MAYBERRY PHASE 1 (ELLICOTT TOWN CENTER)

PUD DEVELOPMENT PLAN/PRELIMINARY PLAN AMENDMENT

LETTER OF INTENT

REVISED OCTOBER 2021

PUD PRELIMINARY SITE PLAN

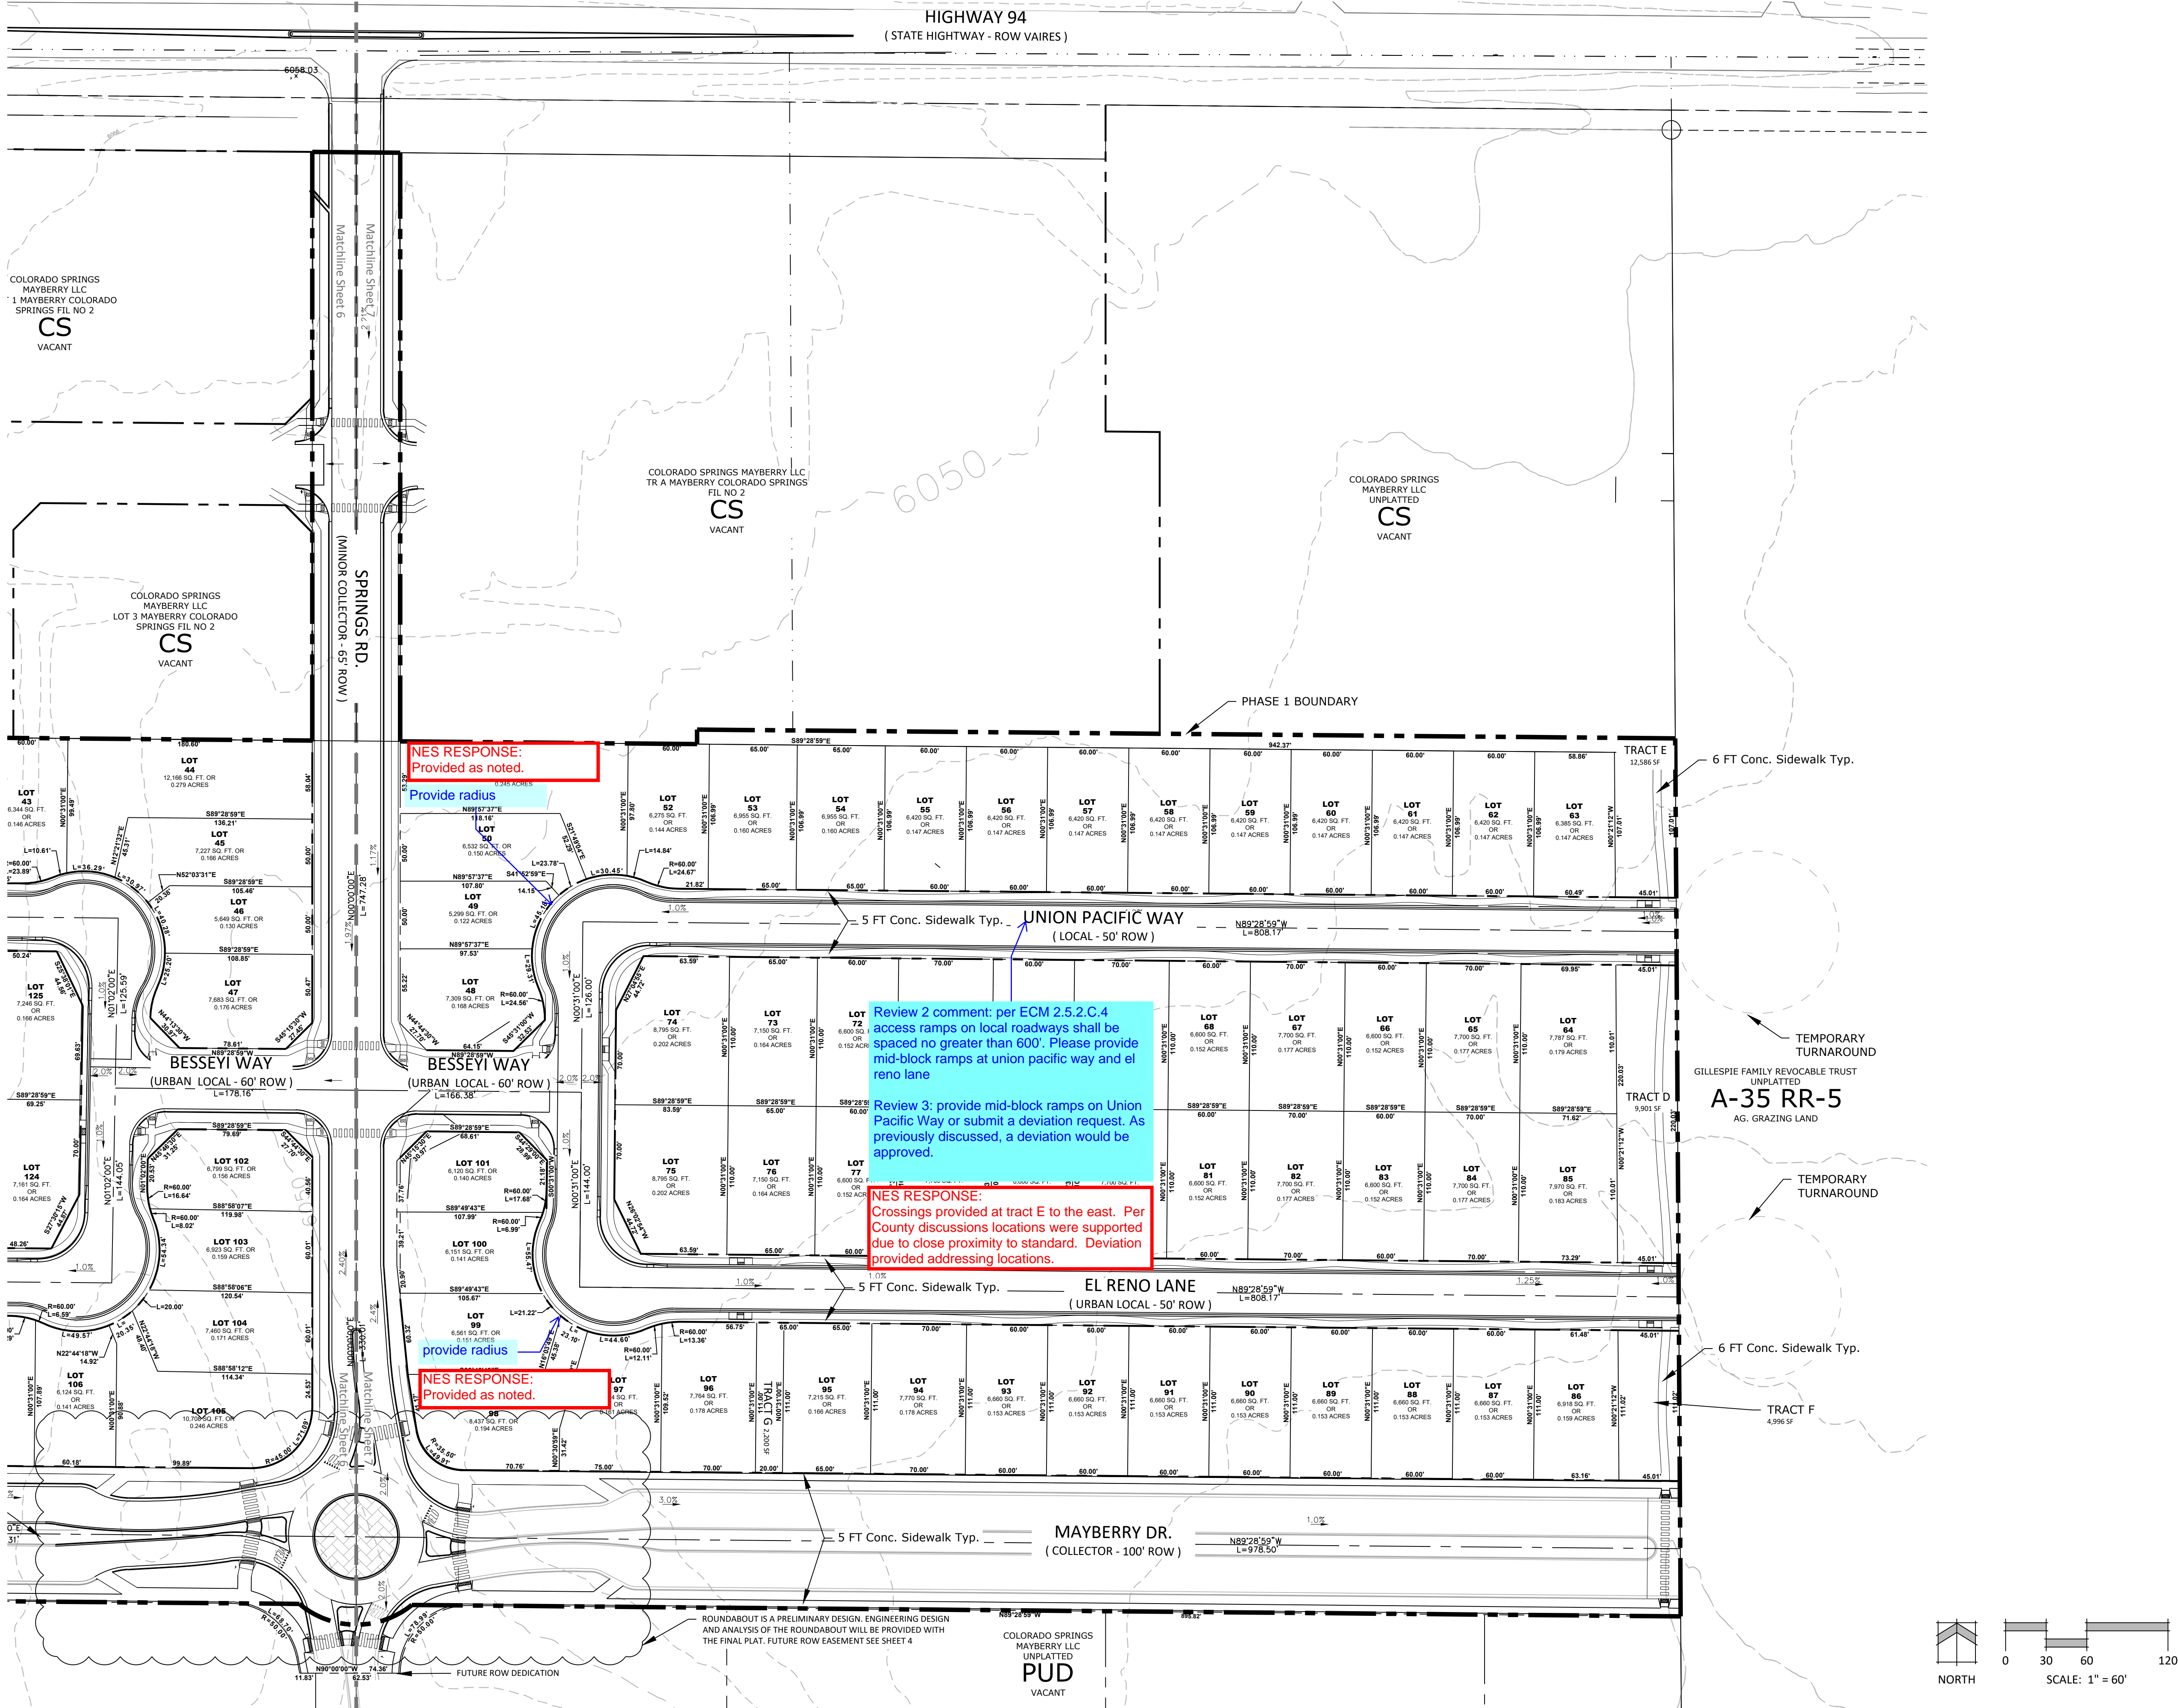
Same comment as on PUD plan: add utility easements

This modification is not listed on the PUD plan

include deviation for mid block crossing if you will be requesting to omit the crossing.

Additional section and requested deviations added.

Additional deviation criteria and justifications added as appendix to document
